City of Albuquerque

July 13, 1988

RE: GRADING & PAVING PLAN FOR EL BUENO SAMARITANO CHURCH (J-14/D76)
RECEIVED JULY 5, 1988

GRADING AND DRAINAGE PLAN
FOR NEW PARKING LOT
EL BUEN SAMARITANO
UNITED METHODIST CHURCH
(7TH STREET N.W. & GRANITE AVENUE N.W.)
ALBUQUERQUE, NEW MEXICO
DECEMBER, 1988

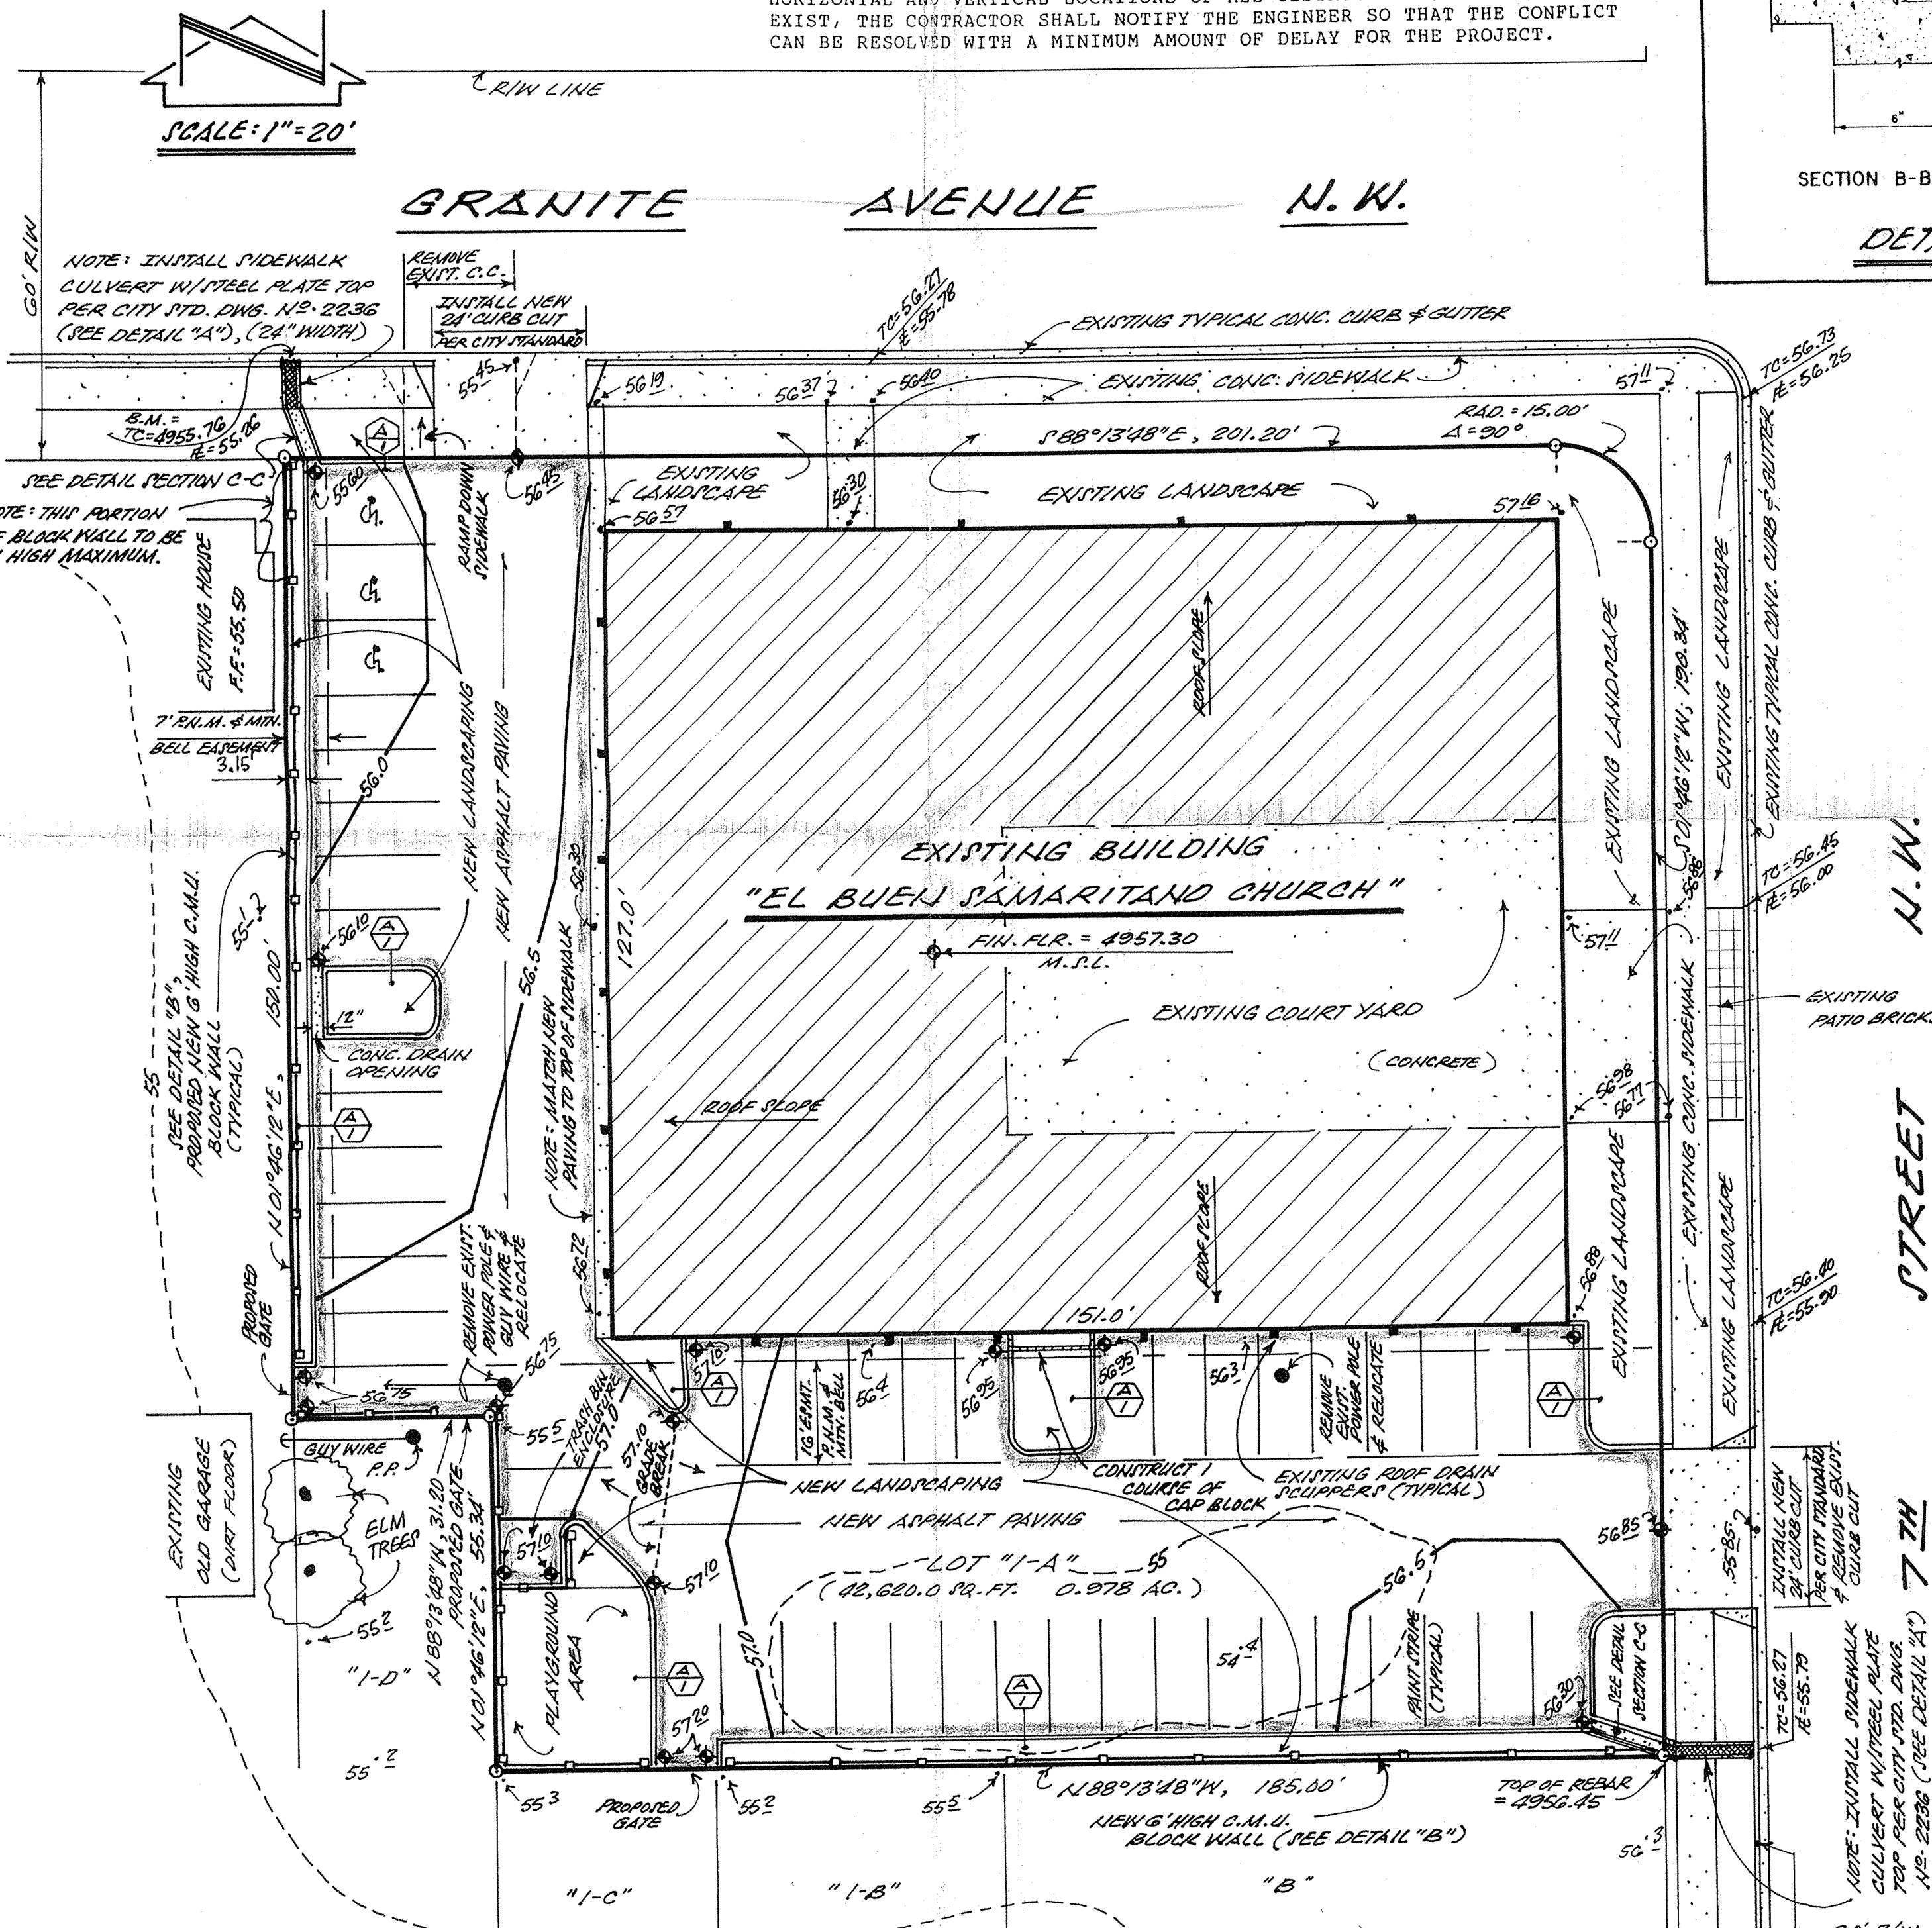
1. ✓ Copy of approved vacation for the alley.
2. ✓ Copy of the approved filed replat.
3. ~~3.~~ Verification of first review by DRC for the proposed manhole.
4. Computations showing the capacity of the proposed inlet. *not done*
5. ✓ Elevation at property line must be at least one foot above property line.
6. ✓ More spot elevation needed within the adjacent lots to the south to demonstrate where the flows are going to (at least 25' past the property line).
